**RE: Estates at Glendale Unit 2
Drainage Report and Grading and Drainage Plan
Engineer's Stamp Date 4-15-16 (File: B19D027)**

Based upon the information provided in your submittal received 4-15-16, the above referenced submittal cannot be approved for ESC Permit (Grading Permit) until the following comments are addressed:

ESTATES AT GLENDALE UNIT 2 AND UNIT 3	DRAWN BY MCM
	GRADING AND DRAINAGE PLAN	DATE 10-19-15
3/25/16		SHEET # ---
DRAWN SCALE P.L. # 14522		JOB # 21422

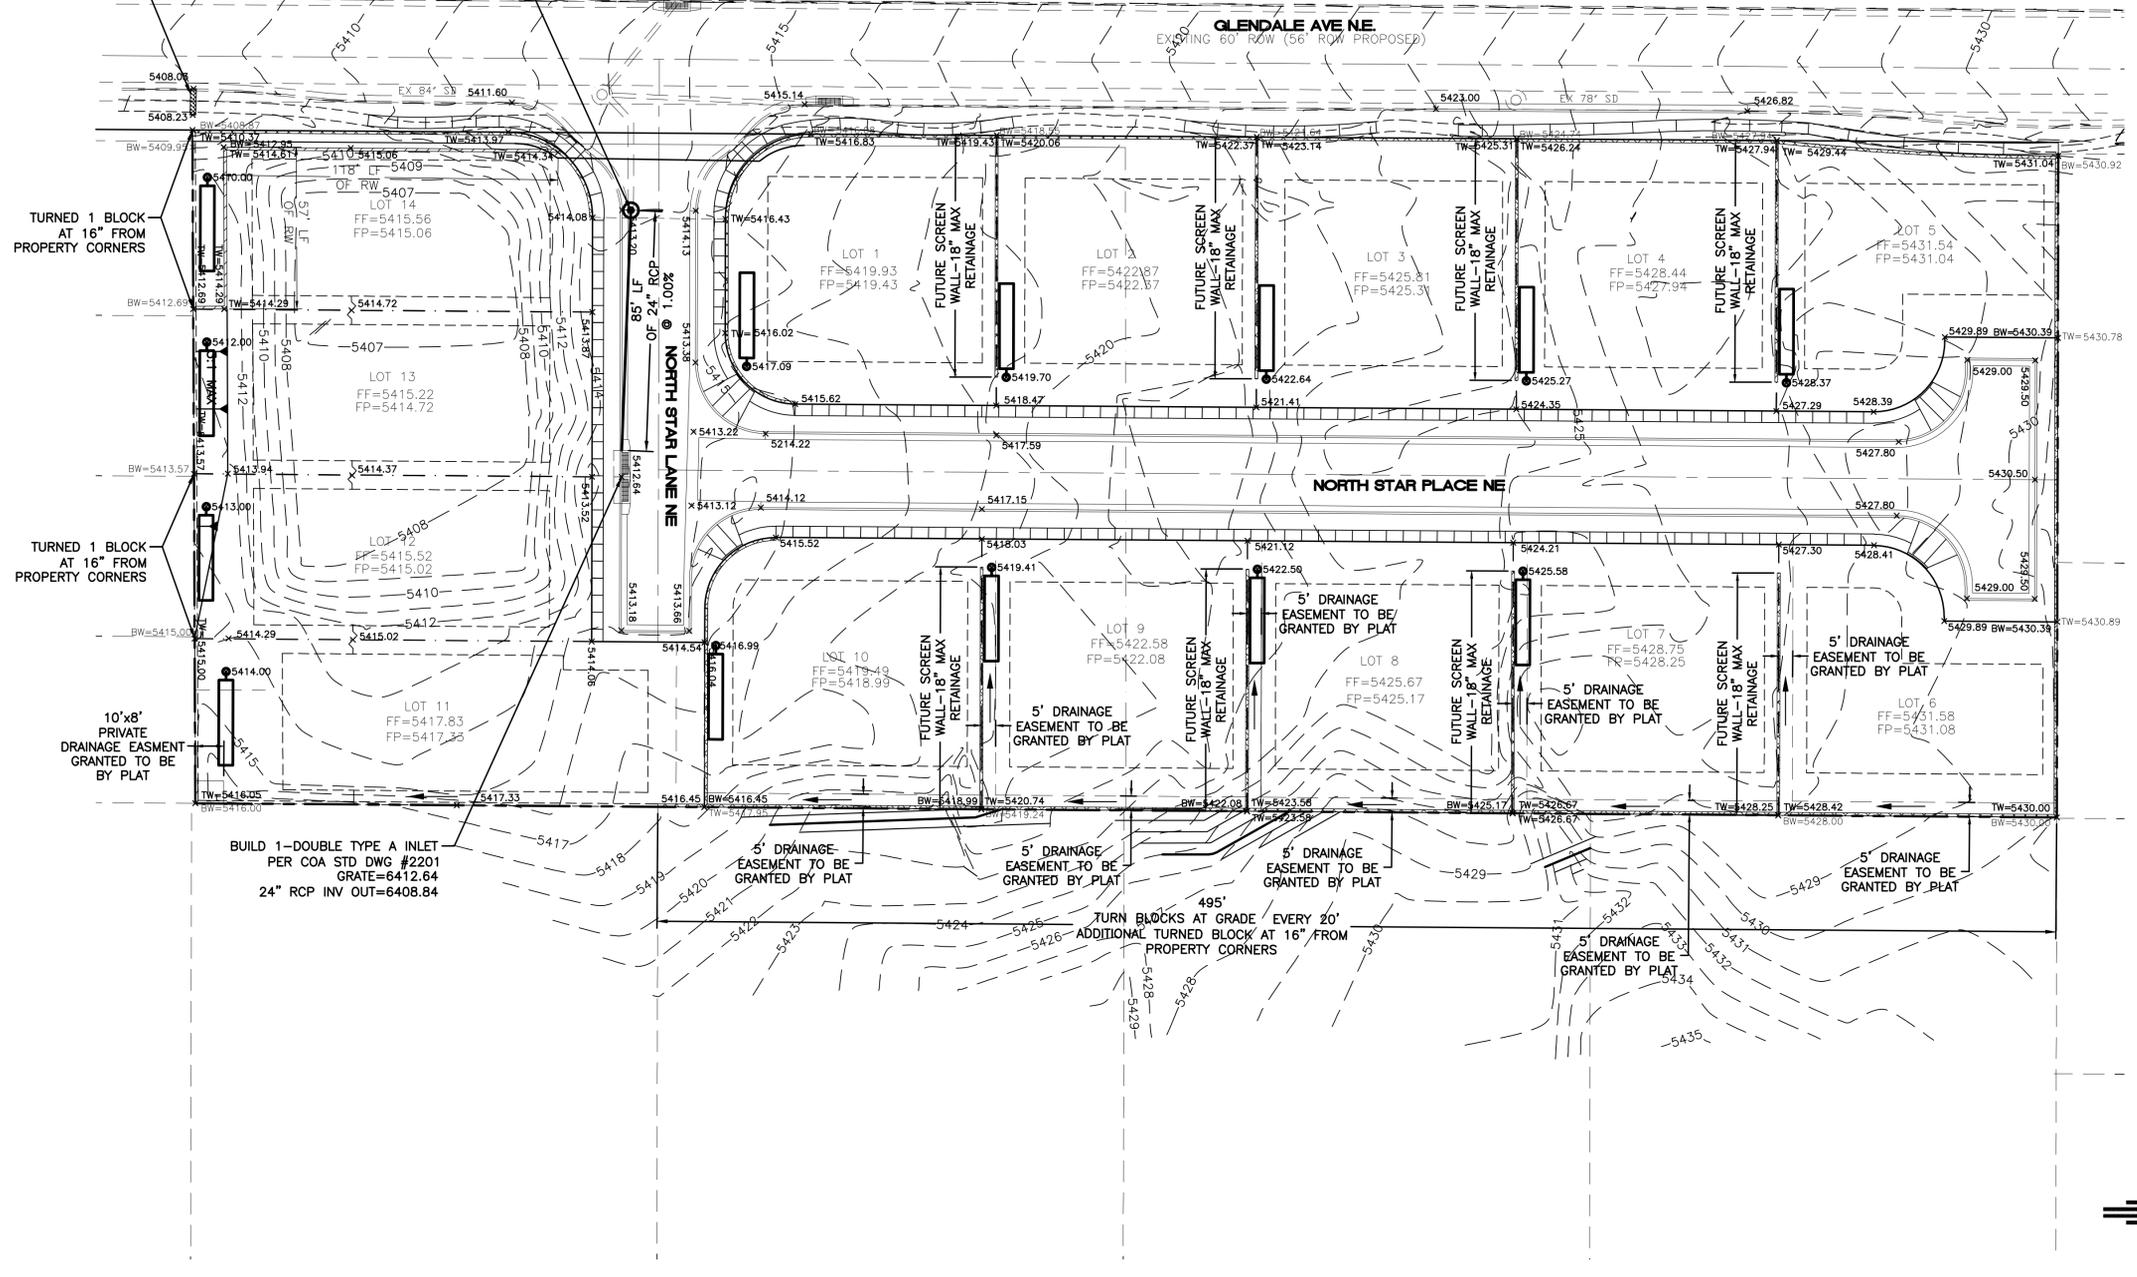
1. Lot 12 SW Corner: Elevation in the existing channel is barely readable.
2. The SW Culvert at NW corner: Both Work Order and Grading Plan show FL. At Curb = 5408.03, but the spot elevation on plan shows 5408.28. The Invert El is 5408.23 but it is not clear if this is the Invert In or Out. Since the FL at curb is shown, I believe it is the Invert IN, please add "IN"(all SW culverts). It would need to be adjusted to be higher than the 5408.28 at the FL.

3. Retaining wall and Wall opening at NE corner:
 - a. How far past the property line is the Retaining wall to be built? What is the T.O.Wall elevation at the end?

- b. The opening also calls for 4'x10' Rip-Rap pad, but it is not shown on the plan. Is future drainage (from the 5' Drainage Easement) supposed to discharge thru the SW culvert? If so then the SW should be in-line with the drainage easement.

- c. The Work Order calls for a 4'x10' Rip-rap pad where the Grading Plan calls for a 5'x10' pad. It is unclear where each pad lies, and the orientation of them as well.

- d. Work order is not defining the location of the SW Culverts, its showing a distance to the edge of the rip-rap.
 - e. What is the elevation of the rip-rap for the emergency overflow at the SW culvert? There are 2 elevations shown, and they are partially covered by the rip-rap hatch. Please clarify.

- f. There is a callout for a 3' opening FL = 23.55, and Section A-A shows a private drainage easement. Is there supposed to be a drainage channel in the future development? If so, the bottom of the future swale/channel would be lower than the retaining wall.

- g. The FG near the opening is 20.84, which implies that the top of the Retaining wall is about 20.84, and a future swale/channel would be too low to discharge out of the opening at 23.55.

- h. The retaining wall along the eastern boundary needs T.O. Wall and B.O. Wall elevations along the wall.
- 4. **Previous comment not addressed:** Fade back existing contours.

- 5. **This comment was not addressed:** Lot 13 South Wall: provide a series of evenly spaced block opening that would allow 4.49 cfs to flow through rather than 1 location of 5 overturned blocks. **New: is the 5 blocks supposed to be 2 blocks? Then there would be 3 locations of 2 overturned blocks and the 4.49cfs from Lot 25 should be divided by 3 and indicated at each location.**

- 6. **This comment was not addressed:** The 1.31 cfs should enter thru overturned blocks on South wall, on undeveloped site. Move location of overturned blocks slightly east so that flows from that site can enter. **New: the opening in the new wall needs to be located on the east side of the lot line between Lots 25 and 26. A 2 ft. opening needs to be provided in the retaining wall along the East property line to allow the flows thru. Show the invert at the wall. Detail how far past the retaining wall the channel will continue.**

- 7. Show the channel slope, the FL Elev. at the East retaining wall, and the FL Elev. where it turns 90 deg. Towards the SW Culvert.
 - 8. The SW culverts needed at end of cul-de-sac: The FL. Elev at Curb is 5415.06 on plan, but build notes show 5415.31. Fix build notes and call out the Invert In elev.
